ENG-SP20008-R3-PDR-redlines.pdf Markup Summary

HOMESTEAD NORTH AT STERLING RANCH
EARLY GRADING & EROSION CONTROL PLAN

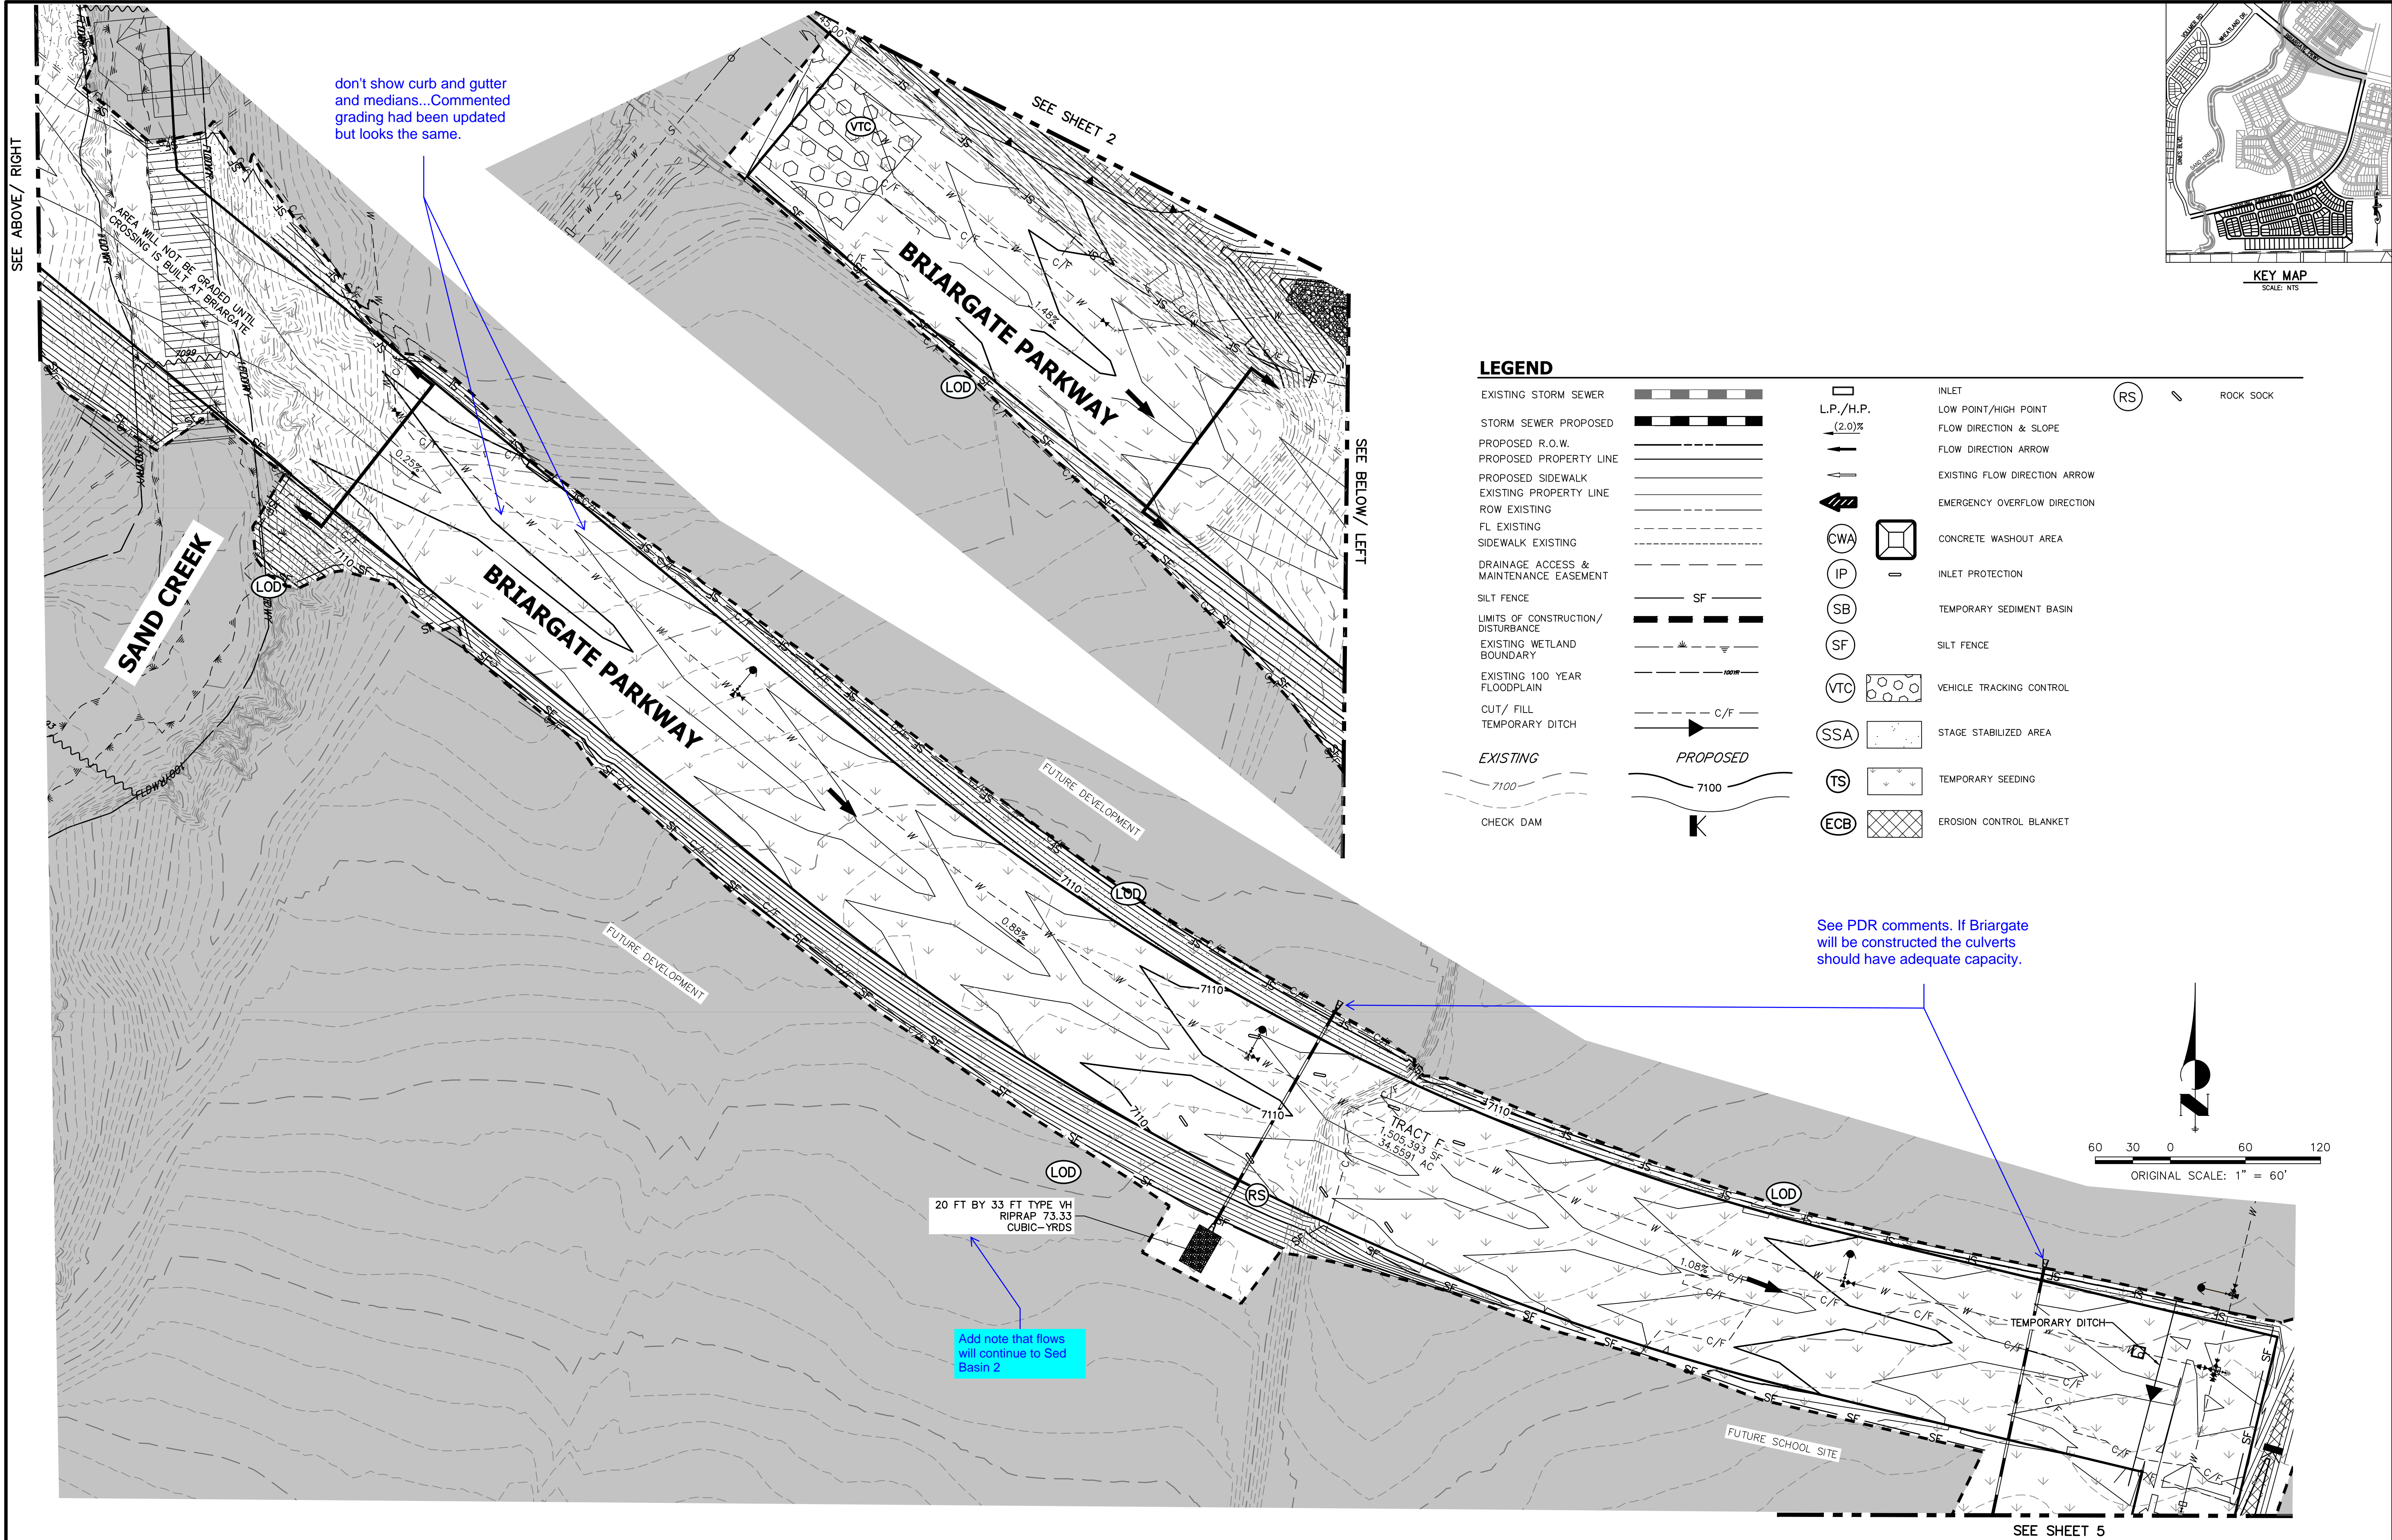
Do not show curb and gutter on grading

The proposed contours should not show curb, gutter and median
